Your reference: 22/00459/FUL

Location: 57 Top Dartford Road, Hextable, Swanley, Kent. BR8 7SG

Proposal: Demolition of the existing house and erection of a 67-bedroom care home including associated access and landscaping works.

Drawings enclosed:
4400 -P5 – Drainage GA
4402-P3 – Catchment Areas Plan

DRAINAGE STRATEGY

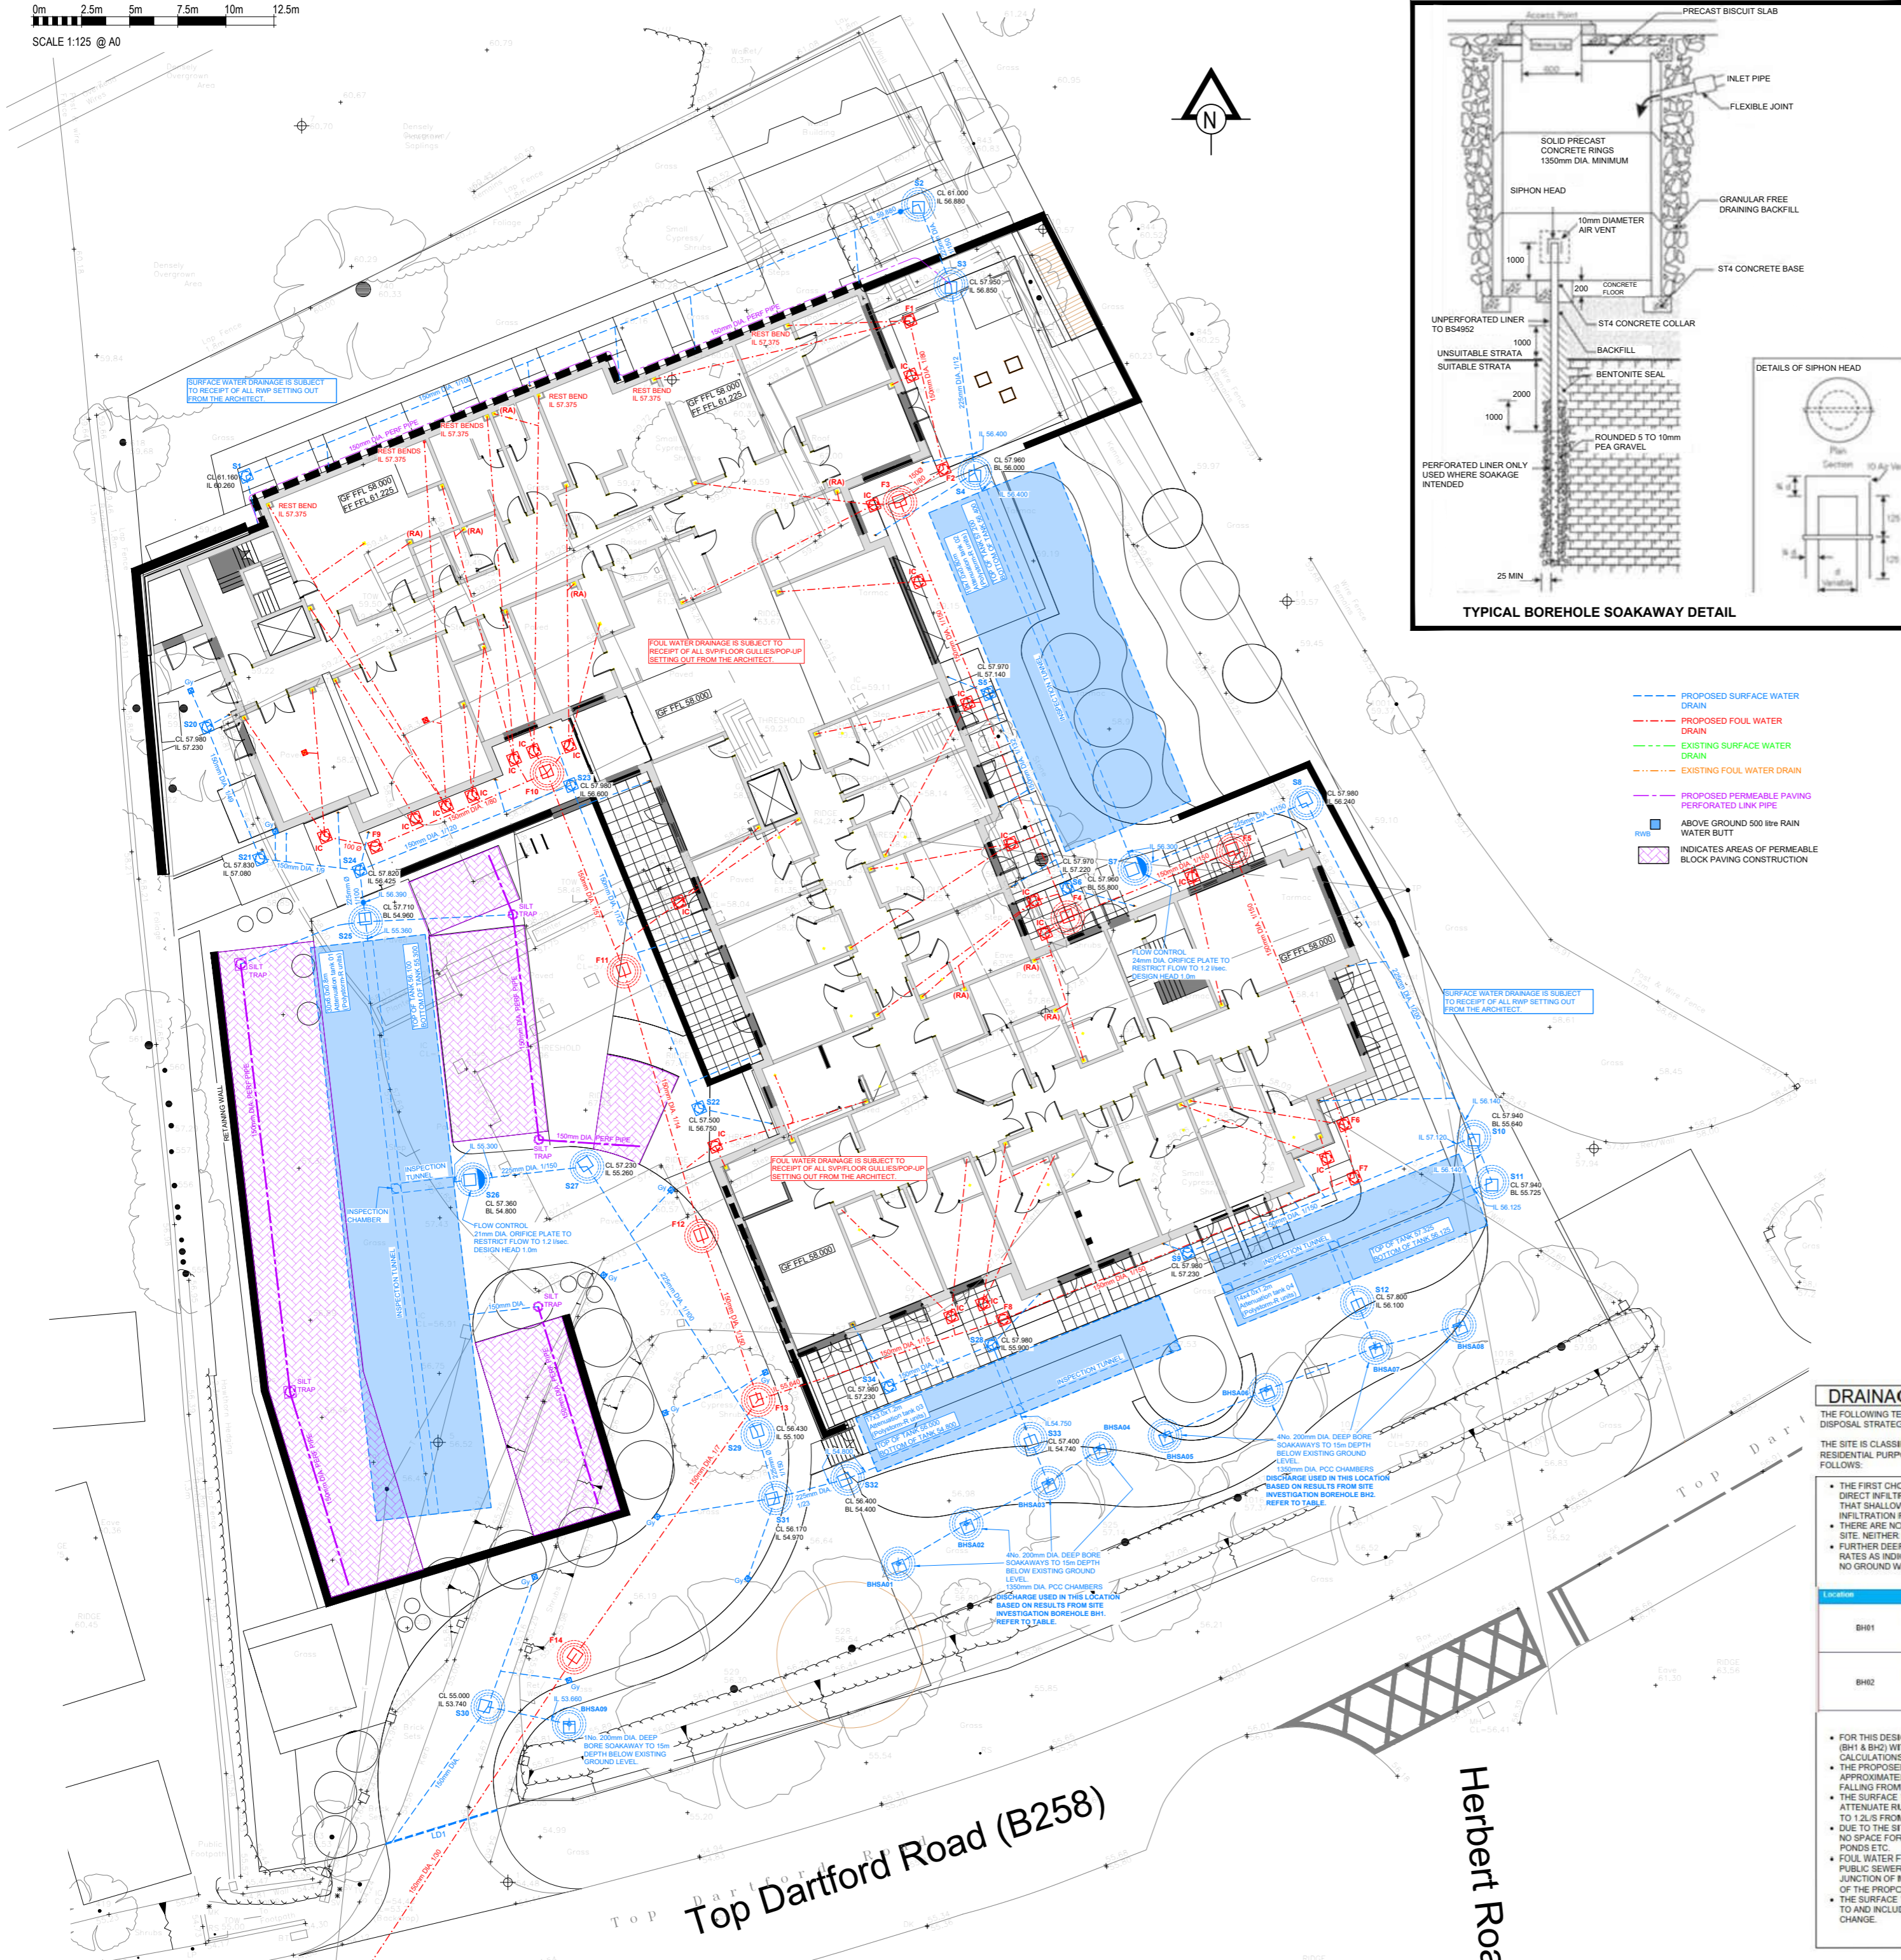
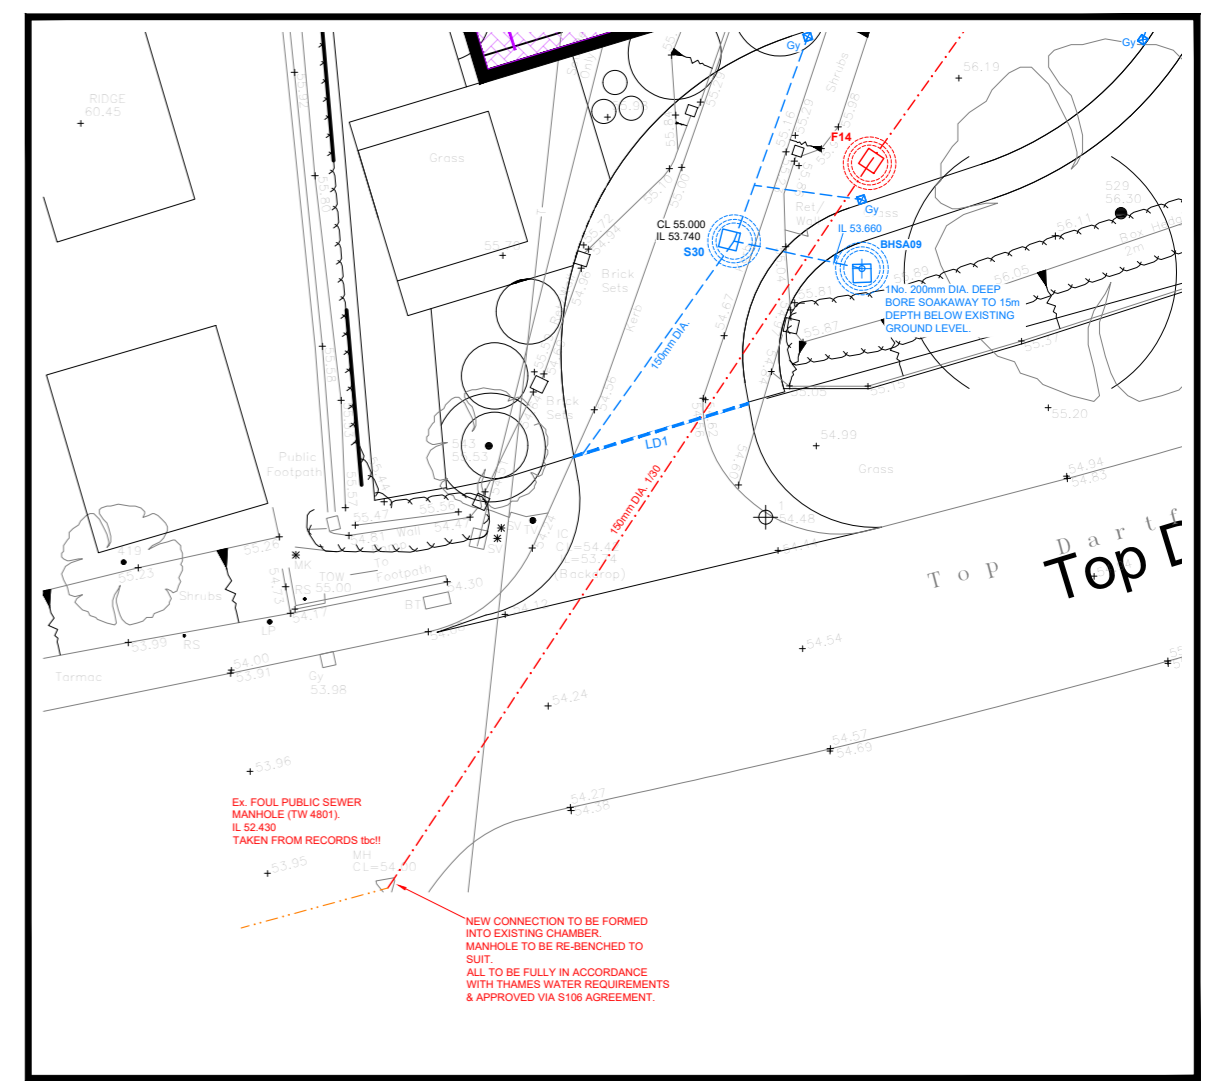
The LLFA were seeking clarification concerning the location of the deep bore soakaways in relation to the proposed foundations for the building structure. It is usual for deep bore soakaways to be sited at least 10m from building foundations. Due to the constraints of the existing trees it is not possible to achieve this distance and the nearest soakaway is approximately 8m to the centre of the BH.

The design of the foundations will take into consideration all the site constraints such as geology, groundwater, geotechnical, trees and drainage. In this instance, the drainage design and location of the borehole soakaways may affect the choice of foundation type and deep foundations or piled foundations may be required where the building is close to the soakaways.

It is standard practice for structural engineers to consider the drainage systems as part of their structural design. However, a note has been provided on the drainage strategy drawing for the designers of the foundations to take into account the location of the soakaways. As a structural engineering practice, we can confirm that a safe foundation solution can be achieved with the soakaways in this location.
